Development Facilitation Team (DFT) – Review Comments

Project No: PR-2023-008660 Date: 5/24/2023 Agenda Item: #4 Zone Atlas Page: H-14

Location: 601 Aspen Ave NW

Application For: SD-2023-00103 – Preliminary/Final Plat (DHO)

**Plat for  
Lot 1-A, Block 5  
Ives Addition  
Being Comprised of  
Lots 1 Thru 4, Block 5  
Ives Addition**

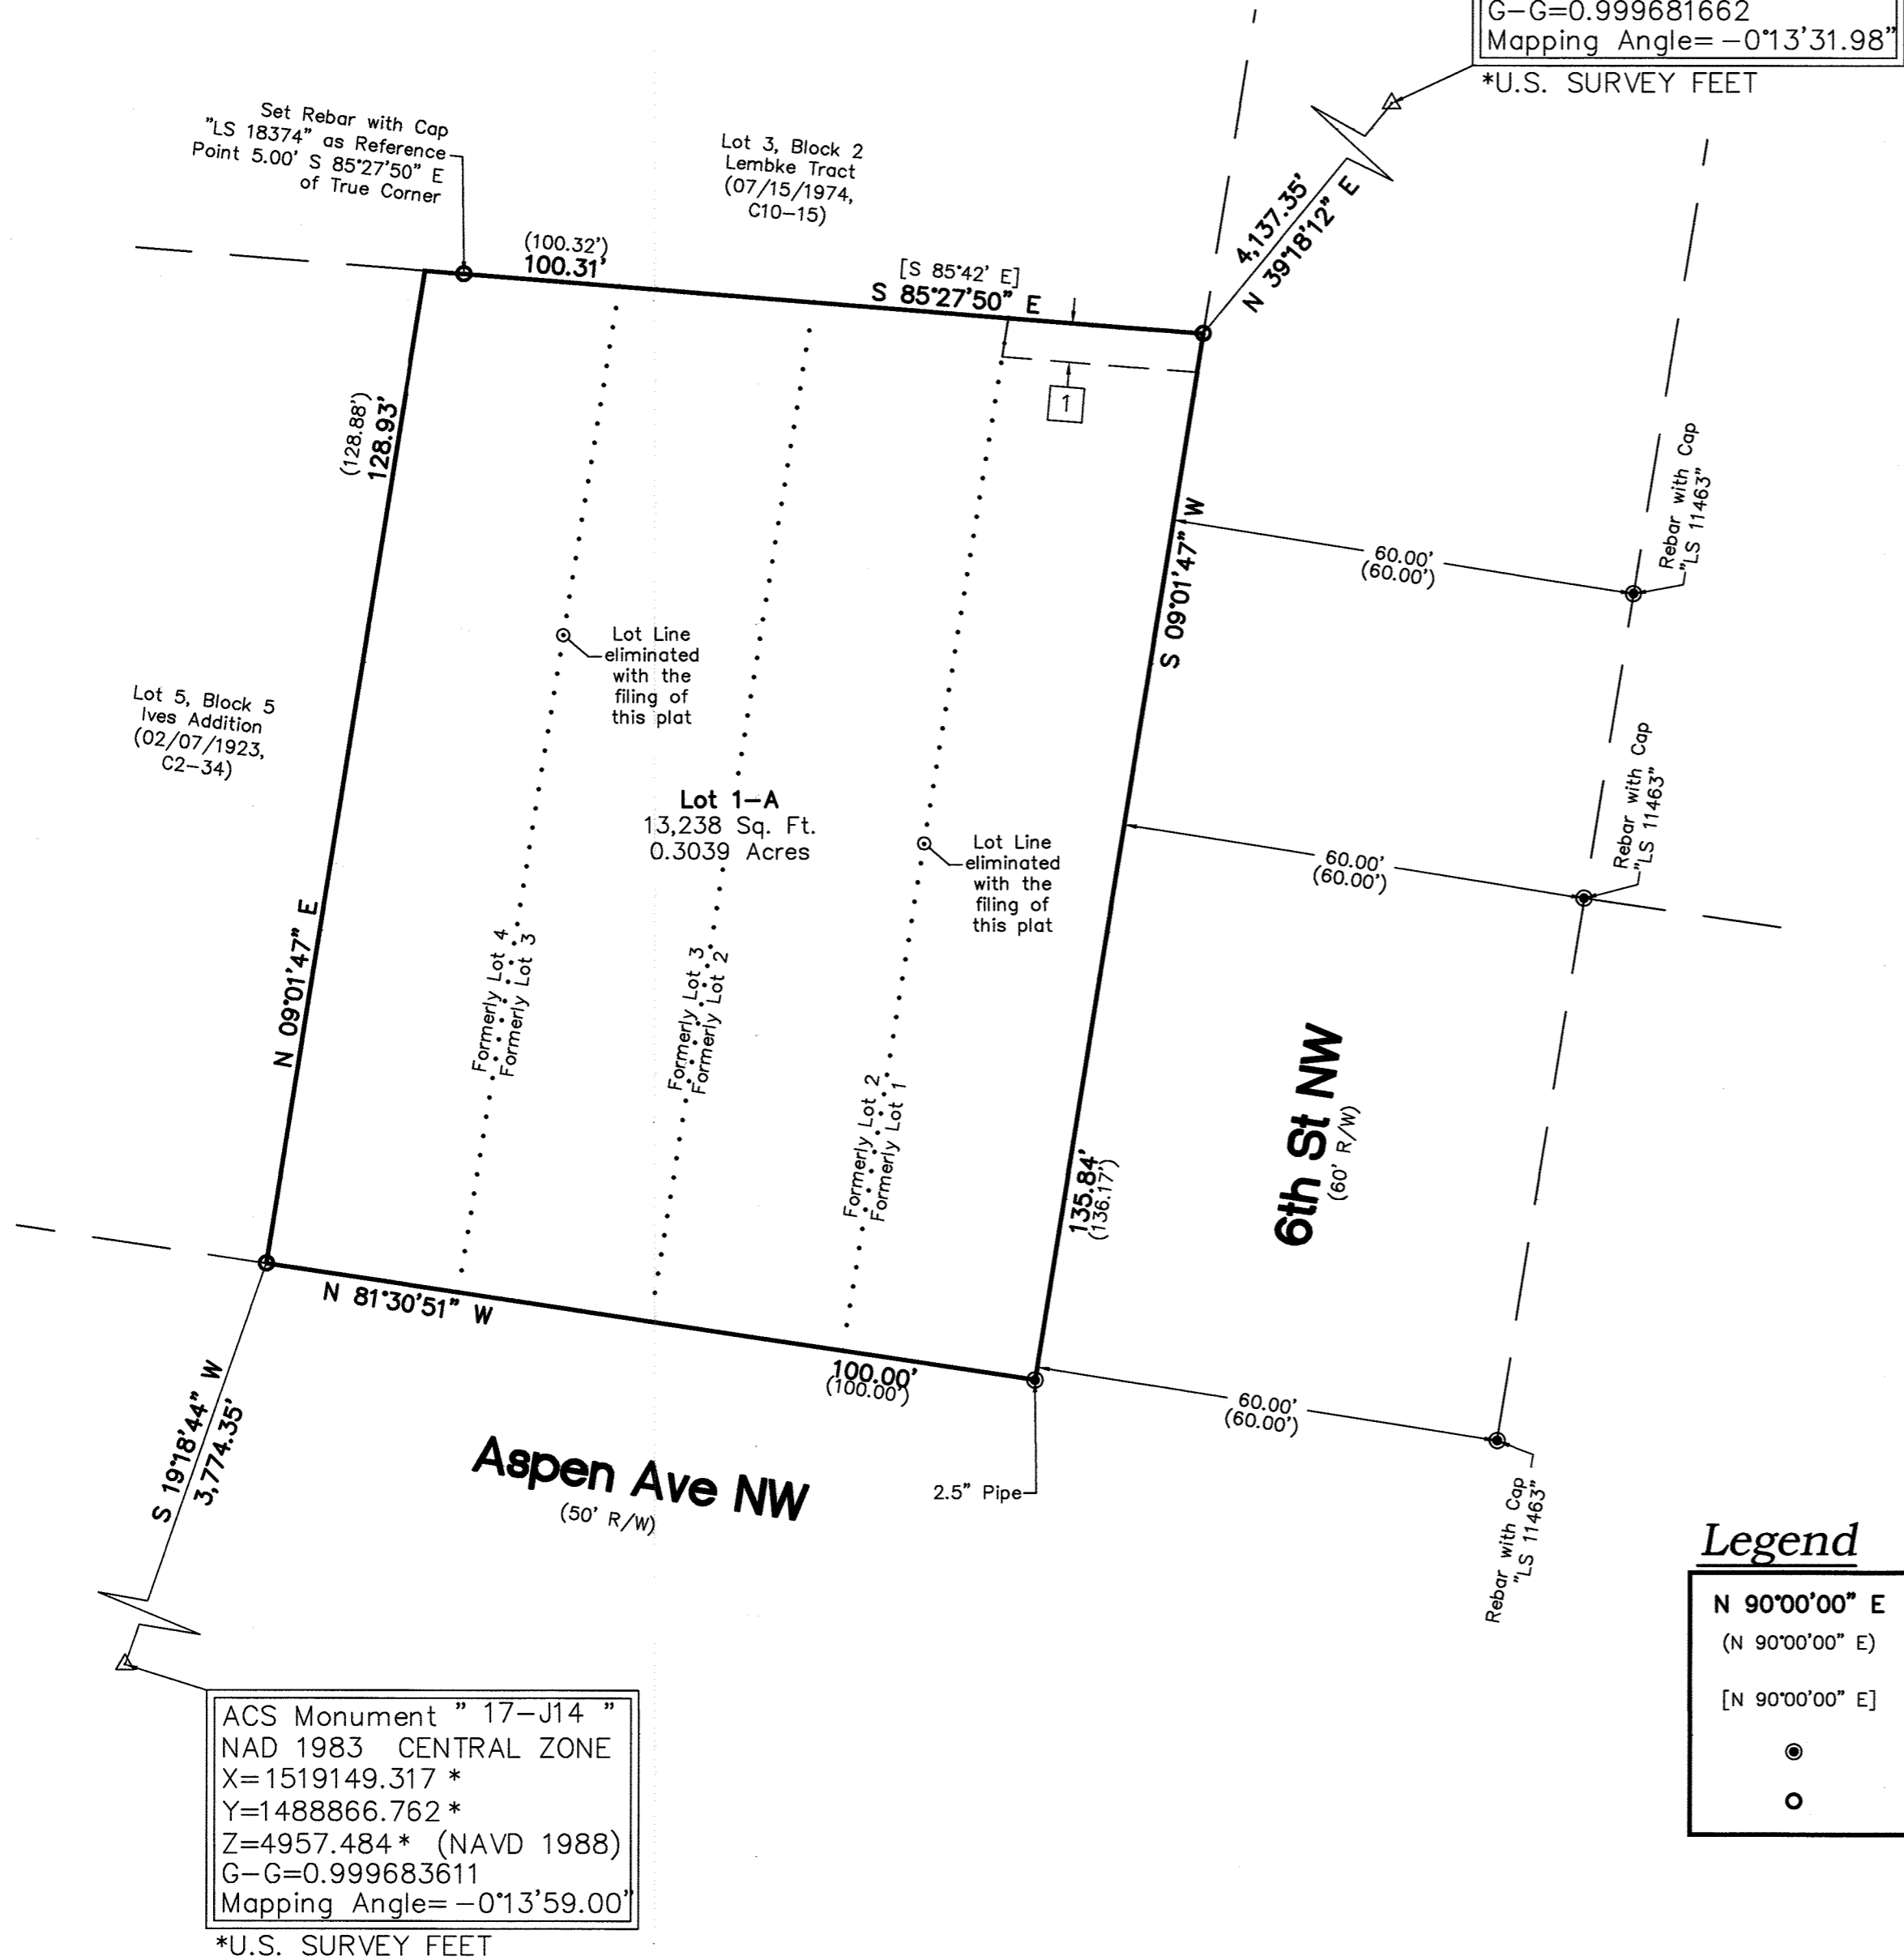
1. The justification for allowing the ROW to remain at the existing 60' is acceptable, given that there is adequate space for future bike lane and sidewalk widening with landscape buffer. Allowing the sidewalk to remain at the existing 5' is also acceptable. No objection.

- The **DXF file** must be approved by AGIS prior to final sign-off should the Plat be approved by the DHO.
- The site fronts on **Aspen Avenue** which is a Local Street. The required Sidewalk along Aspen Ave. is 5ft and the required Buffer Zone/Landscape zone is 4-6 feet. The existing sidewalk is 3.4 feet.

The site is also bounded by **6th Street**, which is a Minor Arterial and has a proposed Bike Lane. Per DPM Table 7.2.29, the required Sidewalk along 6th St. is 6 feet and **the required Buffer/Landscape is 5-6 feet**. The current sidewalk is 5 feet.

- A Justification letter of DHO Determination to request allowance of existing 5-foot Sidewalk and 60 feet right-of-way is submitted with the application. The Planning staff defers to Transportation for final approval.
- Given the determination to retain the existing sidewalk, **the landscape buffer (with street trees) must be provided on 6th Street. This would be on the inside of the sidewalk and within the right-of-way. The installation of this landscaping should be a condition of approval of this plat, or a landscape plan for this area must be approved with this plat that would be executed when the site plan connected to a building permit is requested.**
